**Consultation Response from KC,
Lead Local Flood Authority**

2026/91251 land off, Meltham Road, Marsden, Huddersfield, HD7 6JZ

Outline application for erection of residential development of up to 9 dwellings, including associated infrastructure works

Date Responded: 08/06/2026.

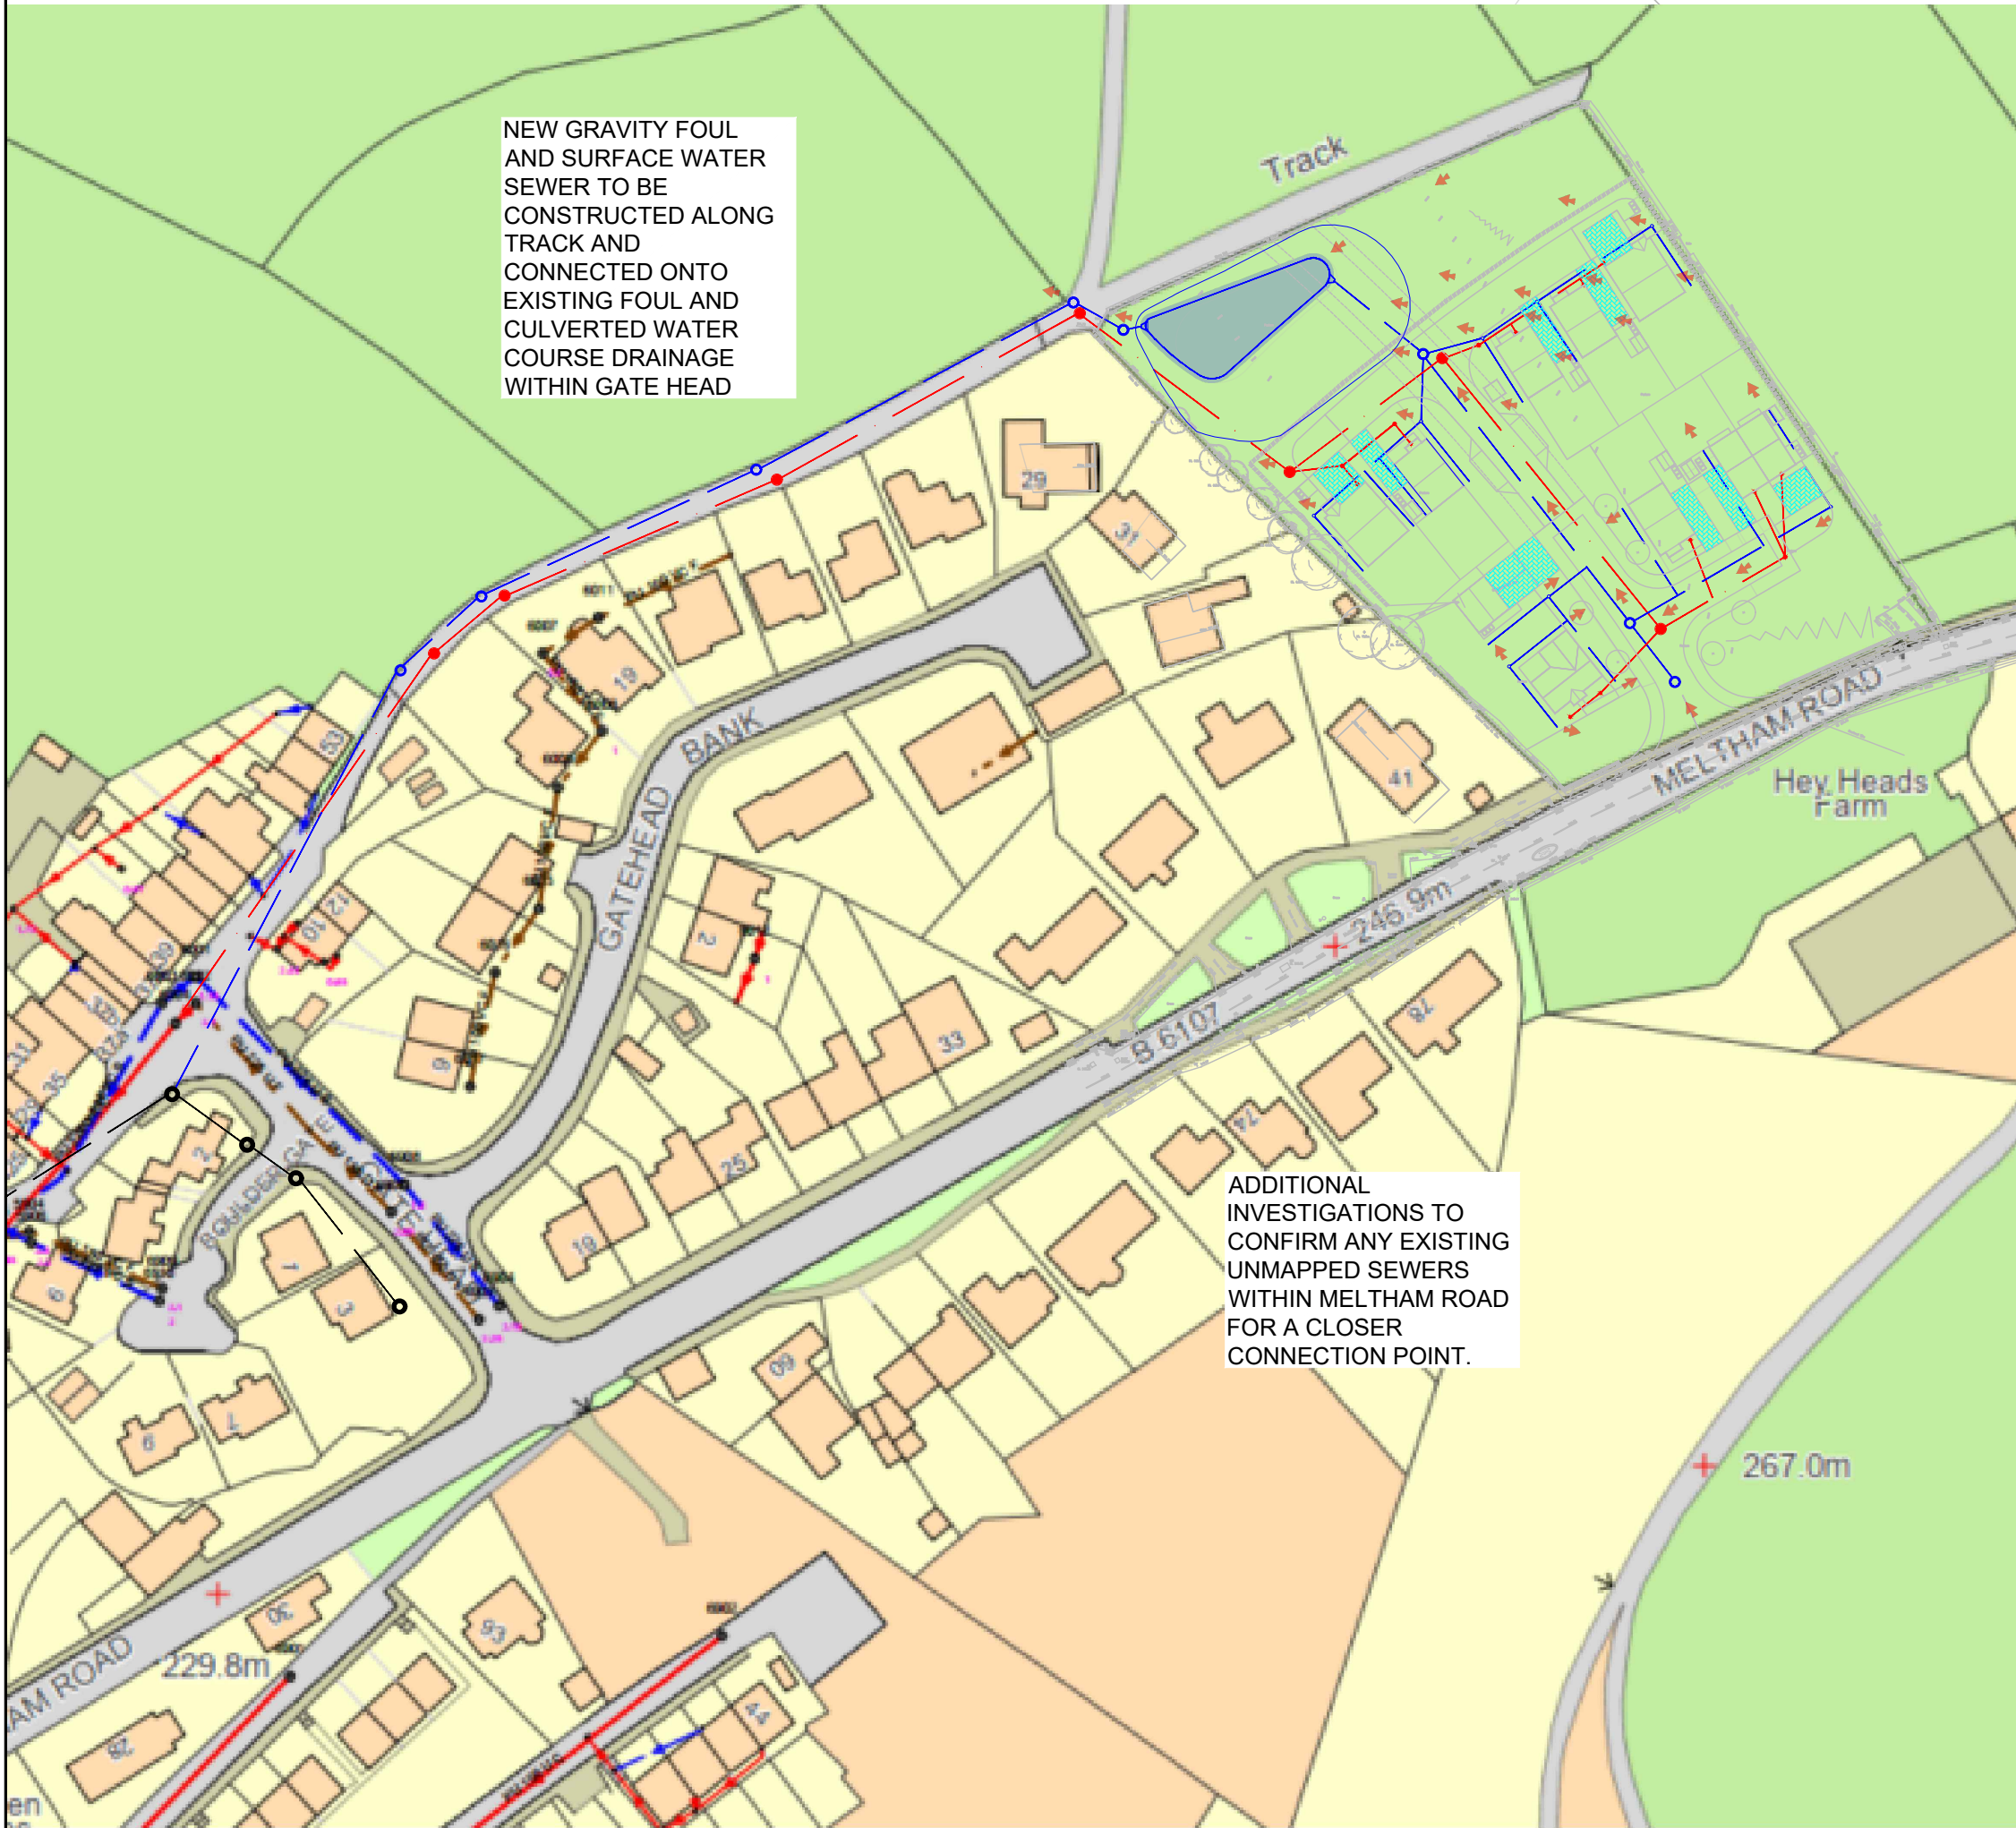
The LLFA confirms that the attenuated surface water discharge rate from the site should be limited to **3.0l/s** and should connect to the Yorkshire Water surface water sewer in Gate Head (subject to YW agreement and 3rd party approvals) as set out in the FRA and Drainage Strategy with storage provided in an attenuation basin on the northern boundary of the site.

Calculations will be required to confirm the drained area and provide details of the attenuation pond (e.g. cross sections stating the maximum water level during the design rainfall event, a low flow channel within the base of the basin, details of the headwalls, etc.).

The final MH upstream of the basin should be a silt trap type to minimise the risk of siltation within the basin.

It is noticed that the hydrobrake detailed in the hydraulic calculations is rated at 2.5l/s, whereas the agreed discharge rate is 3.0l/s – revised calculations should therefore be submitted (unless the developer wishes to reduce the agreed rate). Note also that the calculations do not confirm that no flooding occurs during the 1 in 100 (plus climate change).

A plan showing exceedance flood routes and proposed temporary drainage provisions during the construction phase should also be provided.
